From: [Haley Mercer](#)
To: ["Chris Cruse"; Justin Turnbull](#)
Cc: [Zach Torrance-Smith](#)
Subject: RE: BL-24-00001 Sligmann
Date: Wednesday, February 21, 2024 11:43:17 AM
Attachments: [2002-16243.pdf](#)
[2016-0488.pdf](#)
[4025_001.pdf](#)
[4030_001.pdf](#)
[B15-P095.tif](#)
[exhibit.pdf](#)

Chris,
In reviewing the Sligmann BLA, we have encountered a bit of a snag. Kittitas Compass GIS shows a County owned parcel (APN:077834) located within the area proposed as Parcel A.

CRUSE & ASSOCIATES  
 PROFESSIONAL LAND SURVEYORS  
 217 East Fourth Street P.O. Box 959  
 Ellensburg, WA 98926 (509) 962-8242  
 1250 DUDLEY LLC PROP.

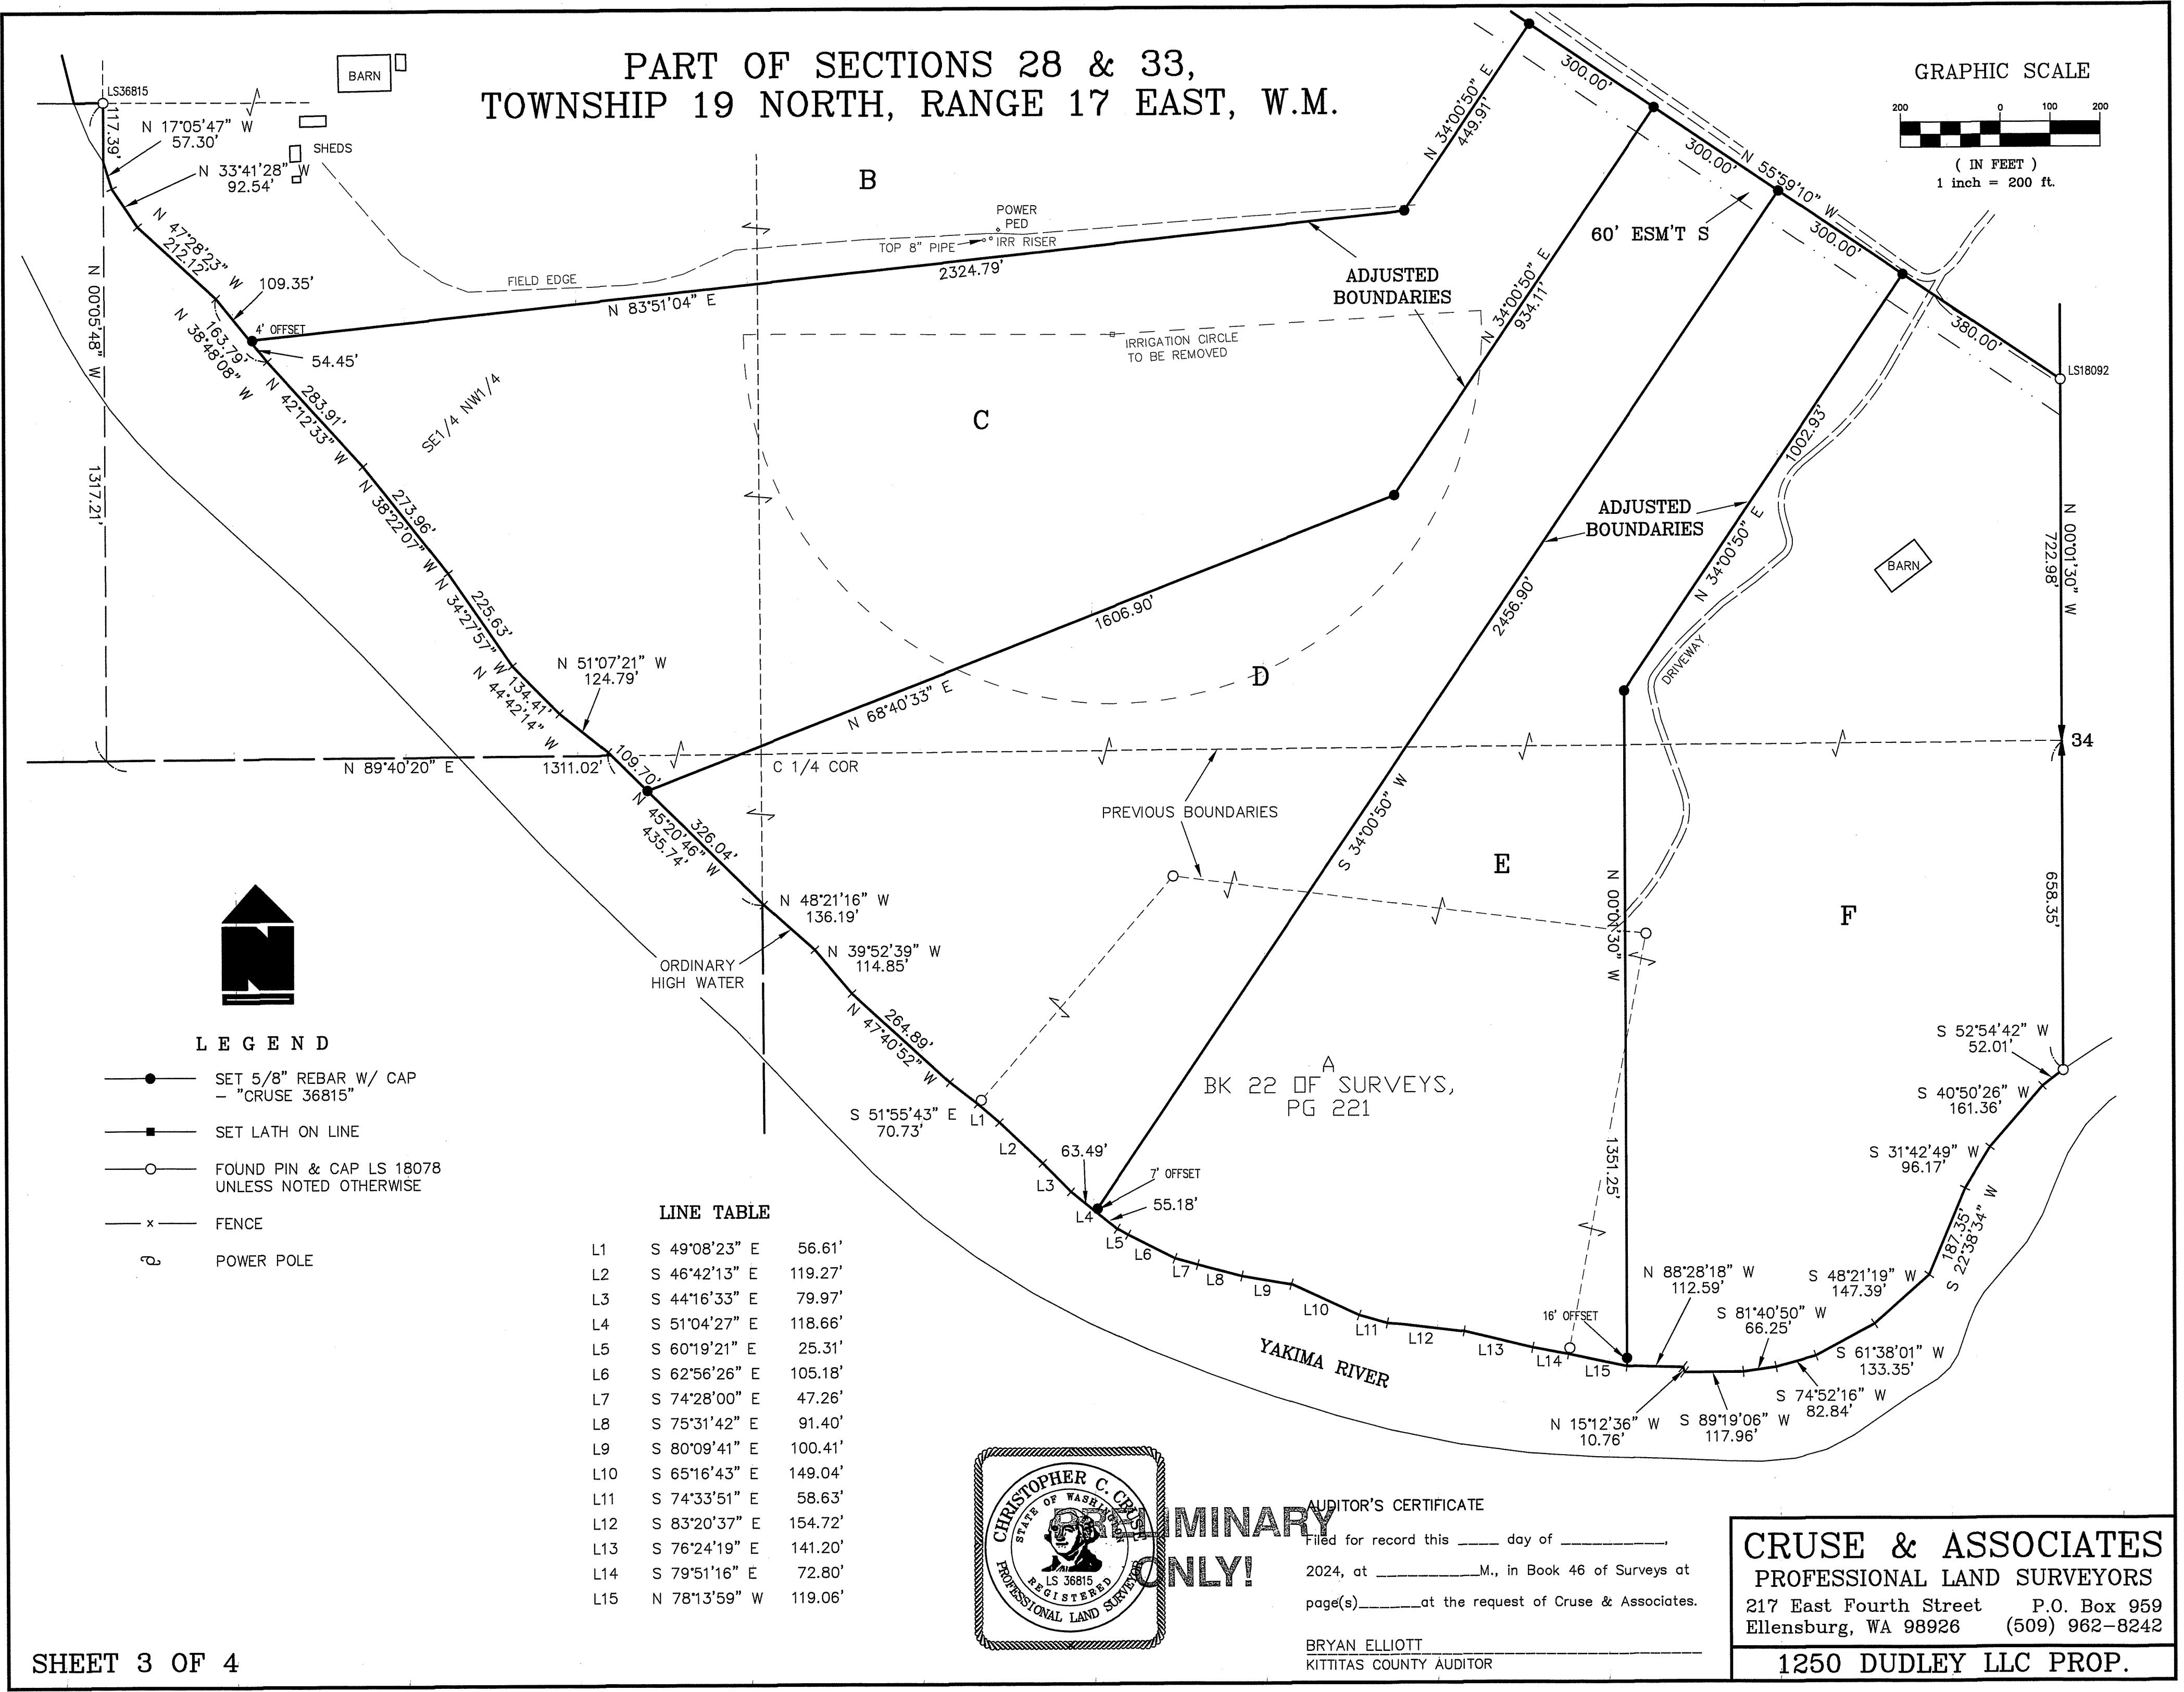
Chris,
I believe this resolves things. While not a requirement, making a note on the face of the survey similar to the note on the prior survey would be a benefit to the public record, and hopefully this whole process isn't repeated next time development happens with this parcel.

Justin - I was not planning on mentioning it on the survey as the descriptions in the title reports for these properties no longer reference an exception for TPN 077834 as apparently it was determined to not affect them.

Haley – Please let me know if the COMPAS mapping is being updated to move TPN 077834 into the r/w. I still may add a note to address if the illustrated tax parcel boundary appears to fall within this 1250 Dudley LLC ownership .
